**KIRKLEES METROPOLITAN COUNCIL
INVESTMENT & REGENERATION SERVICE**

DELEGATED DECISION TO DETERMINE PLANNING APPLICATIONS

Reference No:	2023/62/92640/W
Site Address:	22, Roman Avenue, Mount, Huddersfield, HD3 3XP
Description:	Erection of single storey side and rear extensions, alterations to roof, rear dormer and external alterations
Recommending Officer:	Tom Hunt

Officer Report

NORTH ELEVATION
1:100

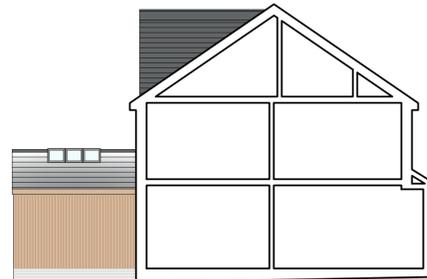
The conversion of the roof would include a flat roofed rear dormer extension clad in horizontal grey composite cladding to similarly match the host dwelling's roof colouring. It would project 3.6m from the roof plane, have a height of 2.45m and width of 5.9m with floor to ceiling windows at rear only.

The single-storey rear extensions would be demolished to have a single-storey rear extension with pitch roof. It would not have any side elevation windows but would have French doors to the rear with a gable end glazing above. This would extend 3.5m from the rear with 5.7m width; the heights would be measured from ground level as: roof ridge (3.5m) and eaves (2.5m). It would be set off from the attached neighbour's shared boundary by 0.3m.

The case officer considered the application on review and sought amendments to remove the front dormer, to have a similarly matching colouring to the rear dormer and to reduce the single-storey rear extension's height. Clarification was sought on materials proposed and additional amended plans to evidence impact on residential amenity.

Sections 5.24 to 5.27 of the SPD provide guidance on the design of dormer window extensions (page 31-32). In this case, the proposal would comply with most parameters being set in from all roof boundaries and similarly matching in colour to the roof tiles. However, it is acknowledged that it would still appear as a dominant design to the rear and there are no roof dormers in the area. On balance, it is considered that this would be mitigated by its own bulk and massing being mostly screened from the highway by the host dwelling’s converted roof. Notwithstanding this, the property hosts full Permitted Development Rights and could therefore construct a rear elevation dormer, including the new roof design, subject to conditions, without the requirement of planning permission. As such, whilst the dormer would disrupt the uniformity of the row of properties, there is a realistic fall-back position and therefore, it is considered that the dormer extension is satisfactory.

Sections 5.1-5.6 of the SPD relate to single-storey rear extensions (pages 23-24). This would replace two rear conservatory extensions which project a maximum of 3.5m from the rear of the host, close to the attached dwelling's shared boundary. While the new extension would not comply with the advice within the SPD limiting extensions to 3m for properties of this type, it is proposed that this replacement of an extension of a similar size closely aligned with the neighbour's existing single-storey rear extension can be accepted as it would not significantly alter the existing relationship between neighbouring properties and would visually improve the current conservatory arrangement by having a cohesive design. The design is of a more solid appearance and a marginally higher roof design adding some additional bulk and massing however offers an improved design to the neighbours with the removal of side elevation openings.

GROUND FLOOR PLAN
1:50

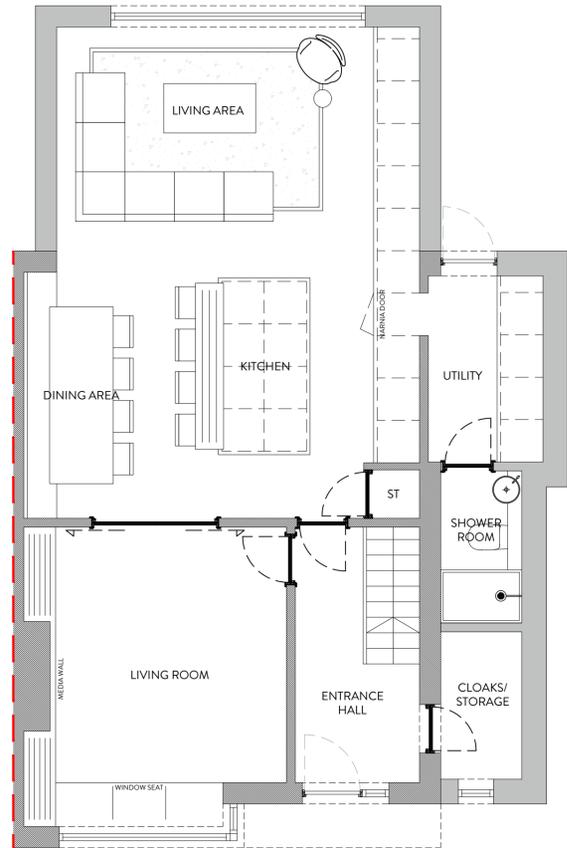
There would be a single-storey side extension to the host property with a lean-to roof design (3.3m ridge and 2.5m eaves height from ground level) including two small skylights. This would be in two sections, to the front it would extend flush with the host projecting 1.5m with a depth of 4.5m; to the rear it would project 1.8m from the side and have a depth of 3.3m. This would have openings to the front and rear, with none to the side elevation.

Sections 5.15-5.18 of the SPD relate to single-storey side extensions (page 28). The proposed design would comply with all parameters except its proposed flush elevation to the host, however, this is considered to be acceptable given its extremely limited projection and the front canopy and bay windows forward of the host property helping to visually 'break up' the appearance of the side extension.
